DRB Application No.: <u>06DRB-01505 (P&F)</u>	Project # <u>1005169</u>
Project Name <u>UNM AIRPORT PARCEL</u>	
Agent: <u>Alpha Professional Surveying</u>	Phone No.: <u>892-1076</u>

2. Project # 1005169
06DRB-01504 Major-Bulk Land Variance
06DRB-01505 Minor-Prelim&Final Plat Approval

ALPHA PROFESSIONAL SURVEYING agent(s) for UNM REAL ESTATE DEPARTMENT request(s) the above action(s) for all or a portion of Tract(s) 10 & 11, **UNIVERSITY OF NEW MEXICO, AIRPORT PARCEL**, zoned M-2 located on IRA SPRECHER RD SE, between LOS PICAROS SE and the ALBUQUERQUE SUNPORT SE, containing approximately 446 acre(s). (P-16/P-17)

DEVELOPMENT REVIEW BOARD – SPEED MEMO

STATION: ACS 1-P17
X = 394206.98
Y = 1460918.14
GROUND TO GRID = 0.99966625
DELTA ALPHA = -00°12'10"
NEW MEXICO STATE PLANE
COORDINATE SYSTEM
CENTRAL ZONE
NAD 1927

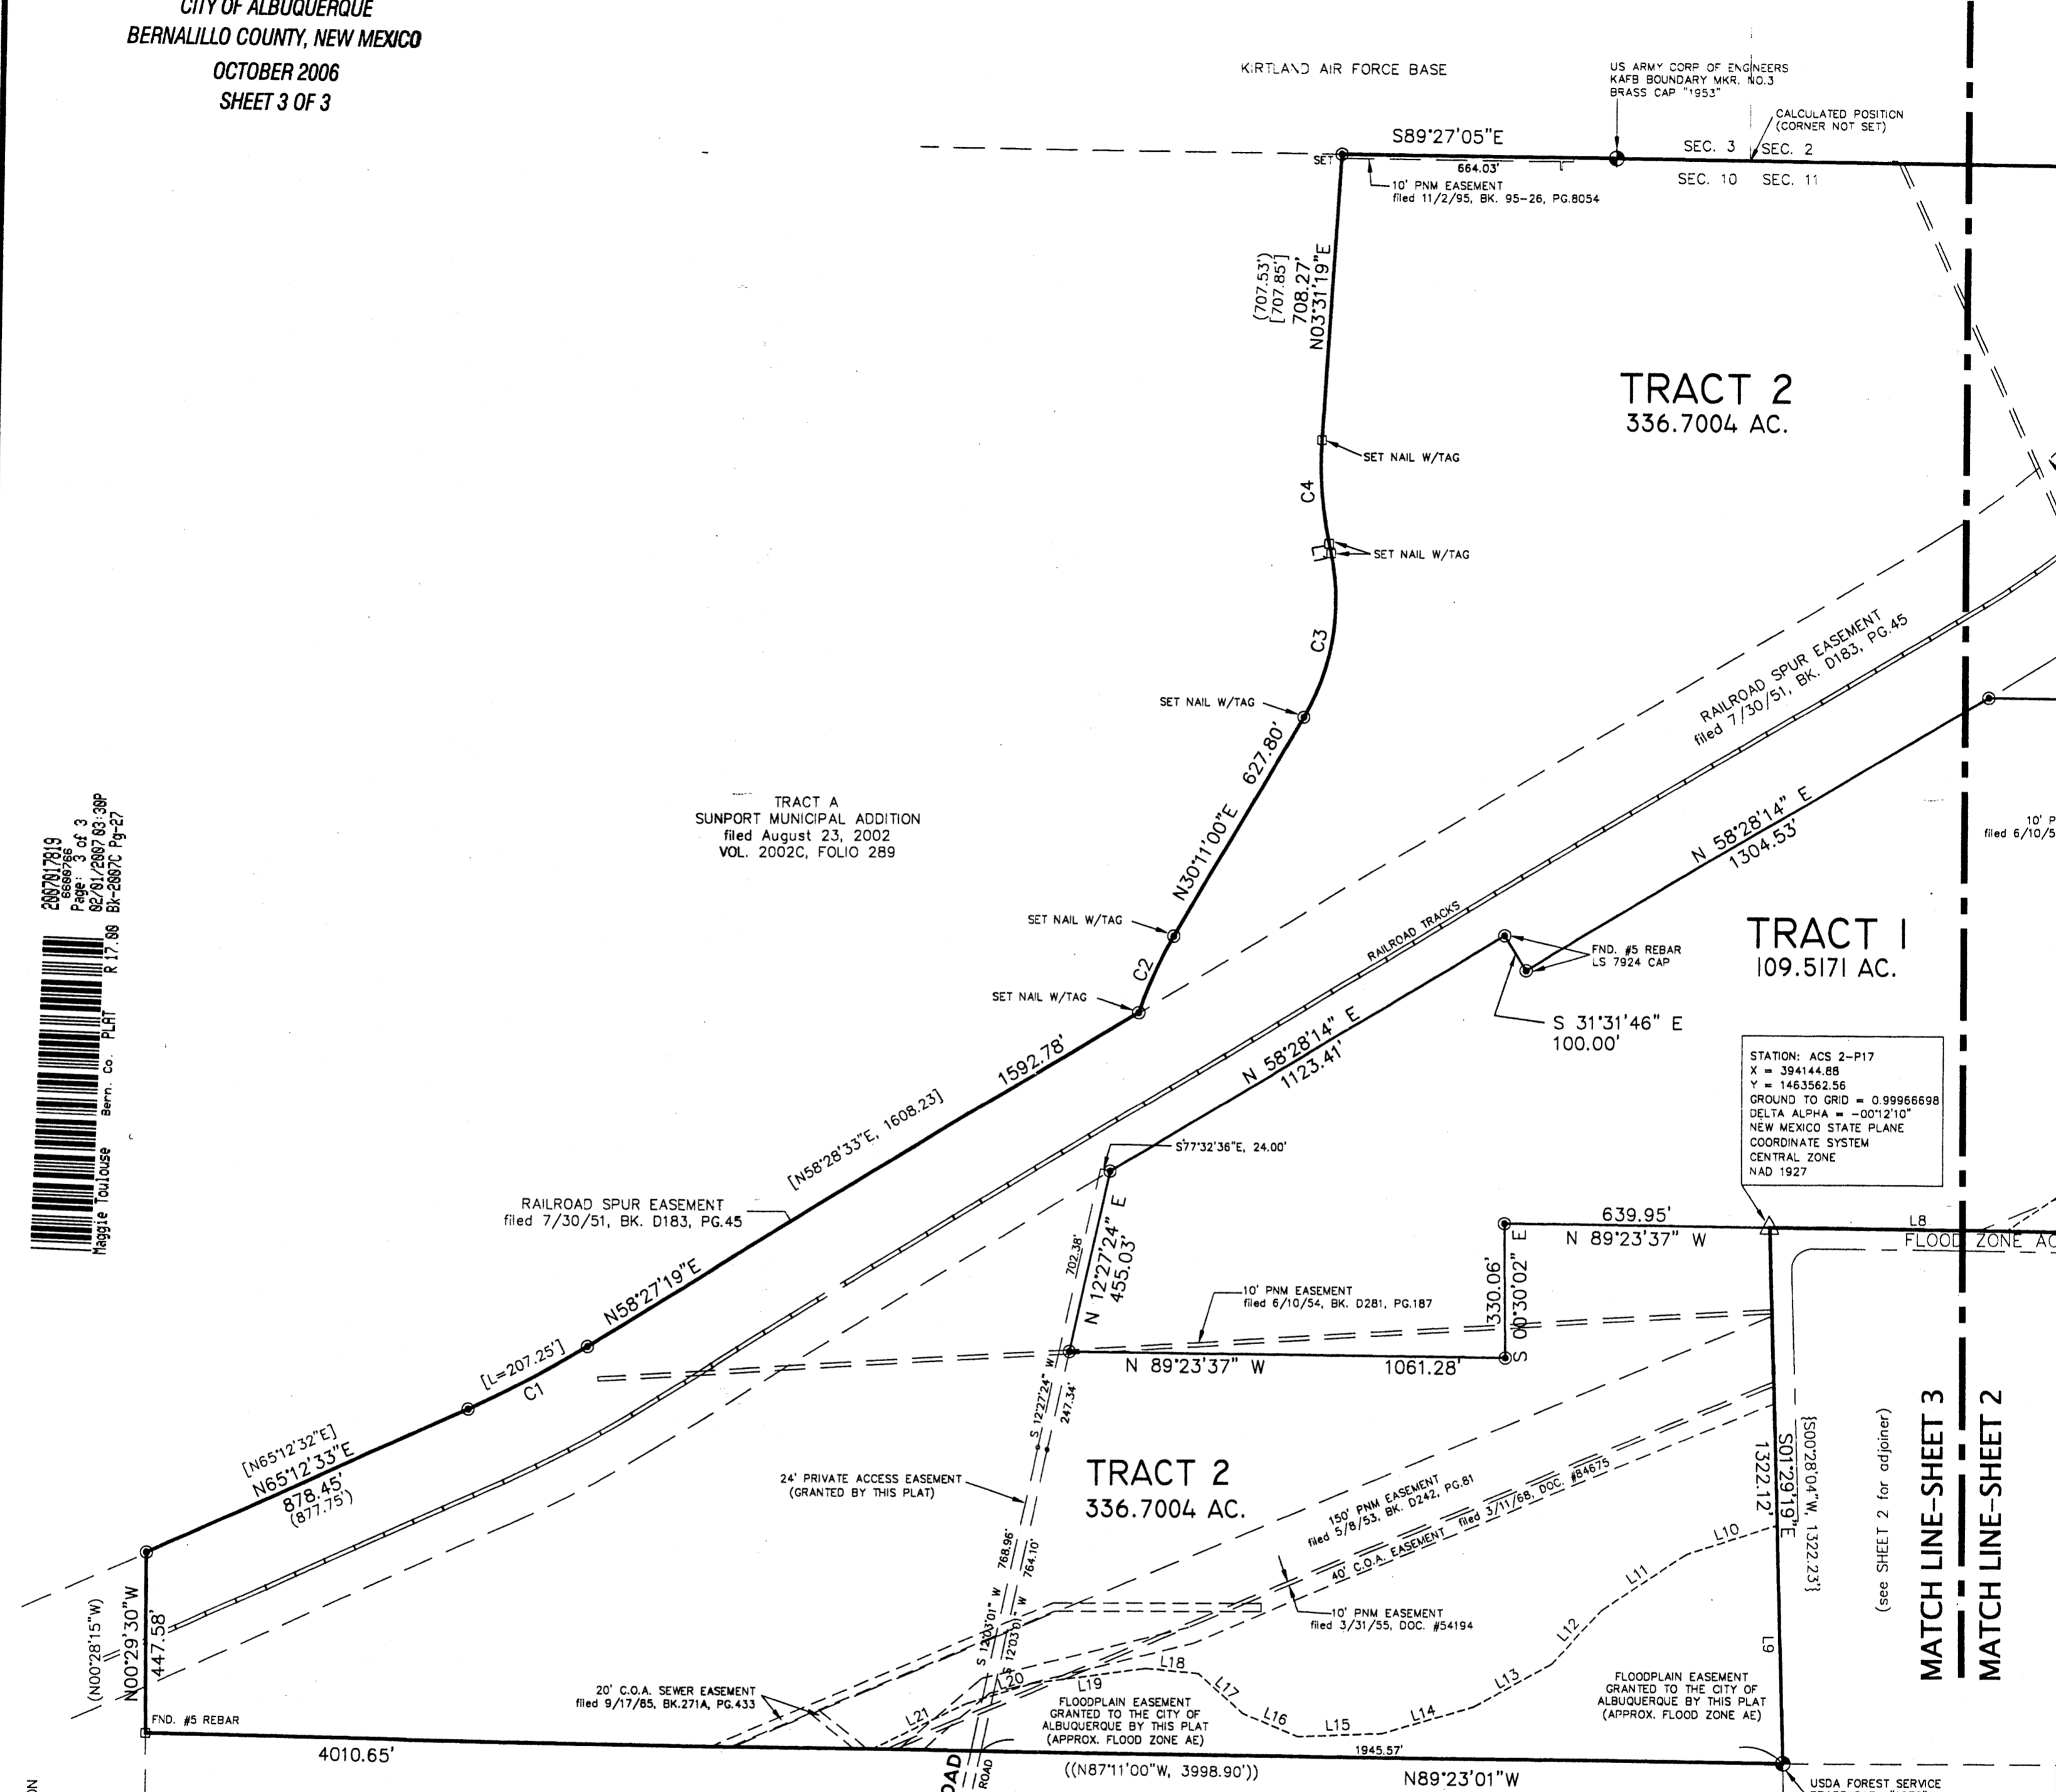
No objection to Bulk Land Variance.
Need floodplain easement(s) granted to the City of Albuquerque.

Where is the documentation for Ira Sprecher Road? How does this alignment fit with the Mesa del Sol master plan? No objection to the Bulk Land Variance.

1. The Subdivision Ordinance requires the owners of land being platted to warrant title to land being subdivided:

2. A separate sheet with the Notice of Subdivision Plat Conditions and the land owner and DRB Chair's signatures must also be recorded with the bulk plat. The Front Counter has the sheet.
